KIRKLEES METROPOLITAN COUNCIL INVESTMENT & REGENERATION SERVICE

DELEGATED DECISION TO DETERMINE PLANNING APPLICATIONS

Reference No:	2023/62/92554/W
Site Address:	717, New Hey Road, Outlane, Huddersfield, HD3 3YL
Description:	Replacement roof and erection of rear dormer with associated internal and external alterations
Recommending Officer:	Lucy Taylor

Officer Report.

Drawn	DRH
Date	April 2023
Scales	1:100 @ A3
Drawing No.	2341 - 0302 - P03

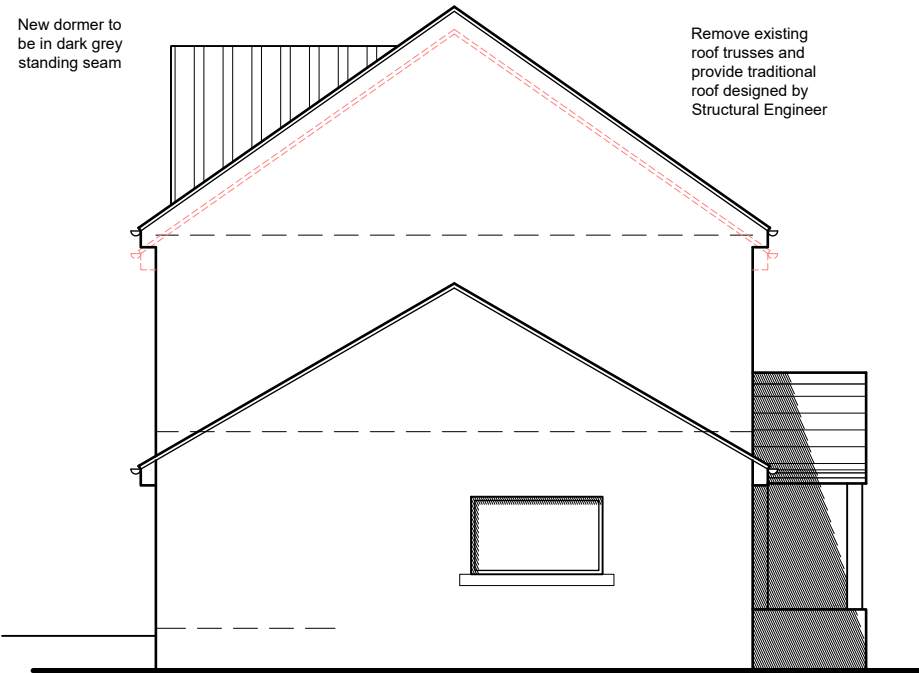
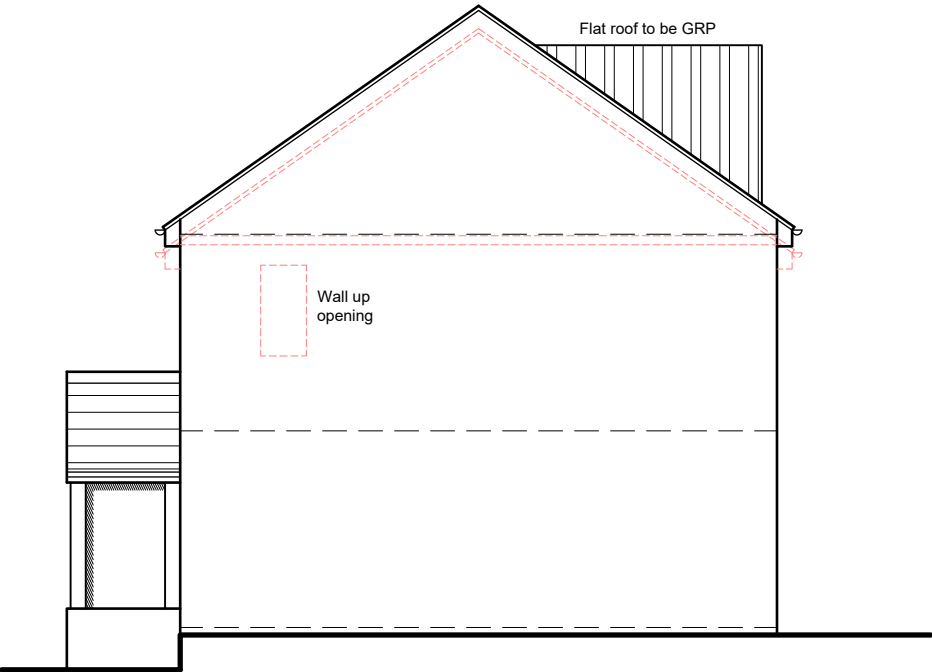
The case officer requested that plans be submitted to demonstrate the increased roof height of No. 717 New Hey Road in conjunction with neighbouring properties.

In response to the case officer request, the applicant/planning agent submitted revised proposed plans, showing the height No. 717 in conjunction with No's 715 and 719.

The applicant/planning agent submitted an amended proposed plan to show streetscene elevations as requested by the case officer.
